Planning Application No: 3/2024/0007

Proposal: Conversion of existing single-storey double garage to annexe and erection of garden shed.

Location: 37 Middle Lodge Road Barrow BB7 9XS

Tahira Akhtar BA (Hons)
Technician
Highways and Transport
Lancashire County Council

PROPOSED PARKING
LAYOUT.
1:500

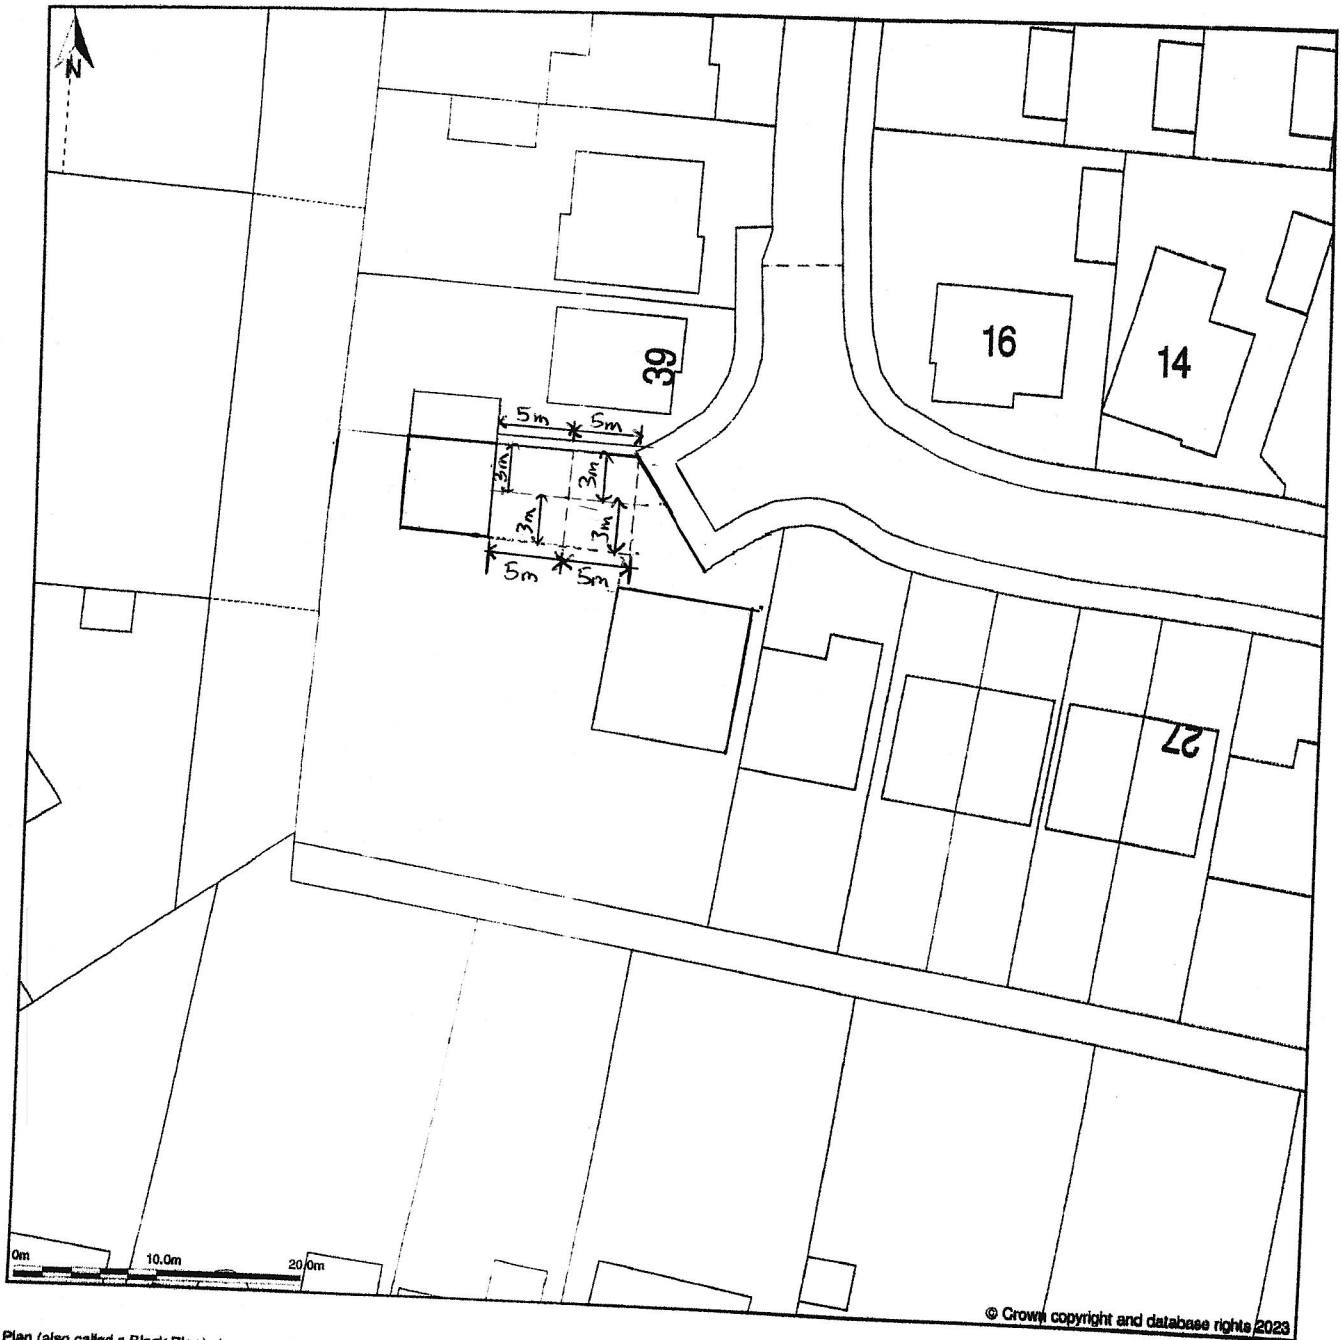
The submitted documents and plans have been reviewed and the following comments are made. An adequate level of off-road parking for the type and size of development proposed will be retained. The highway authority is of the opinion that the proposed development will not have a significant impact on highway safety, capacity or amenity in the immediate vicinity of the site.
